## Eagleview Subdivision Traffic Impact Study

(LSC #S214750)

December 3, 2021

<sup>2</sup> Please add PCD File  
 # SP-21-06

Figure 2
Site Plan

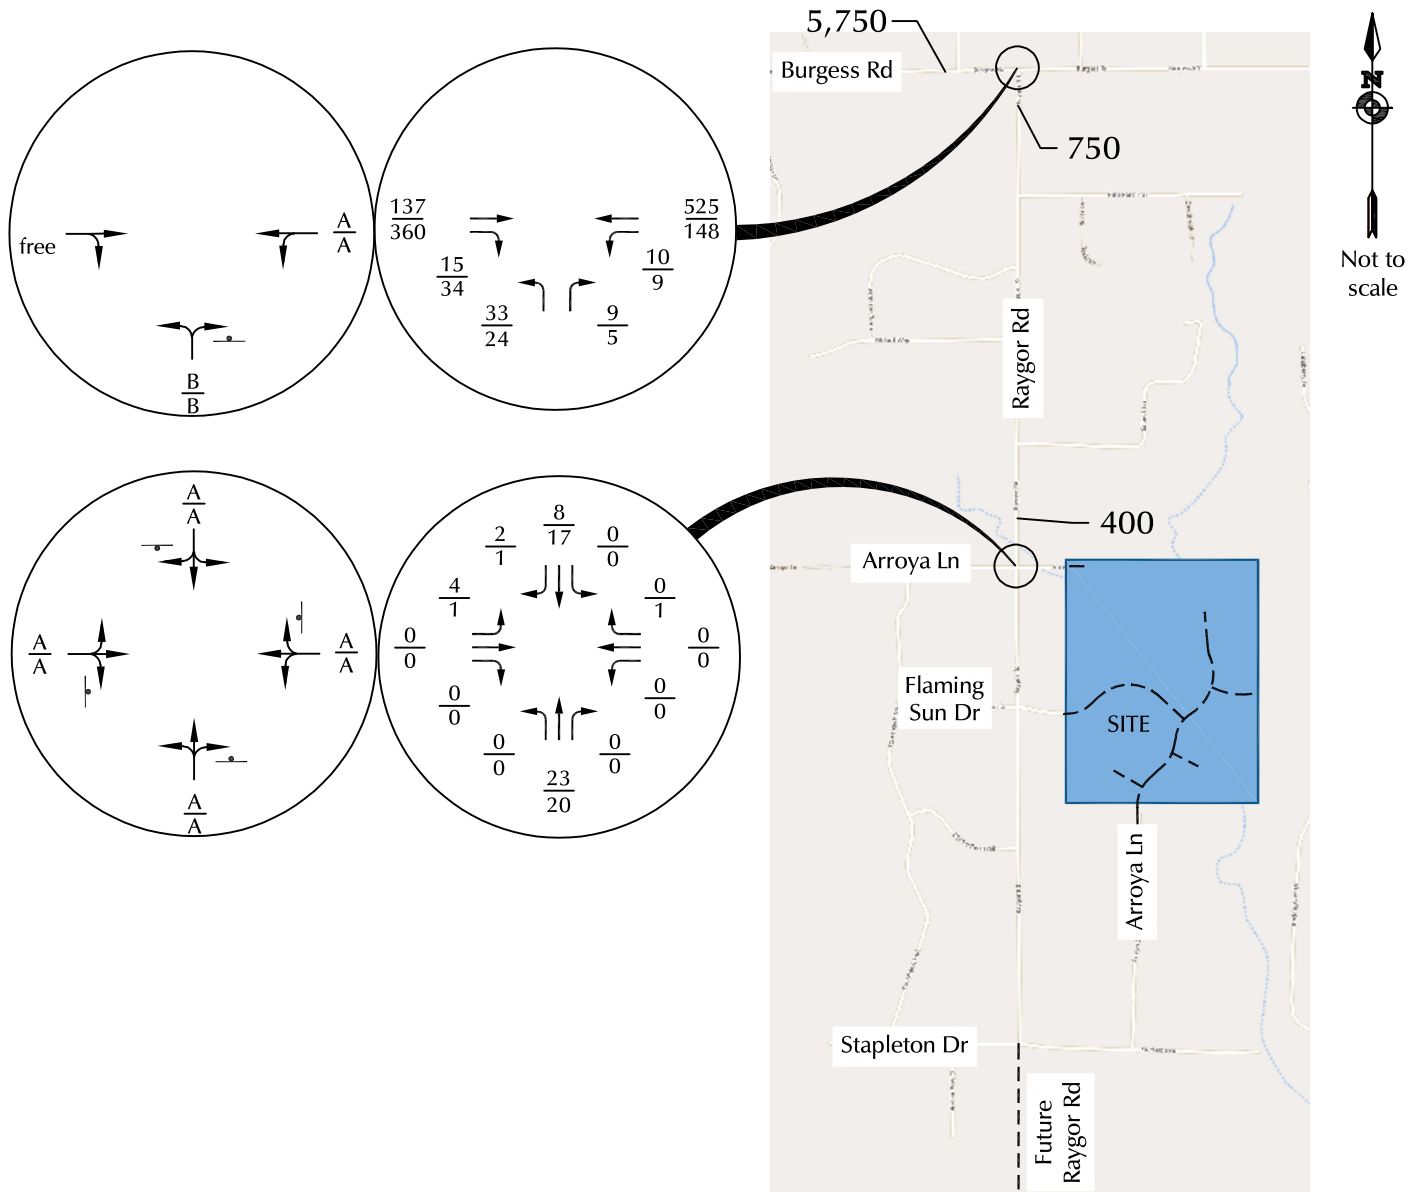
Figure 2 shows the site plan. The site is located within unincorporated El Paso County. The site is planned to be developed for 38 single-family residential dwelling units. Access to the site is proposed via three existing intersections:

Proposed site access (and existing) intersection centerline spacings are shown in Figure 2 and are as follows:
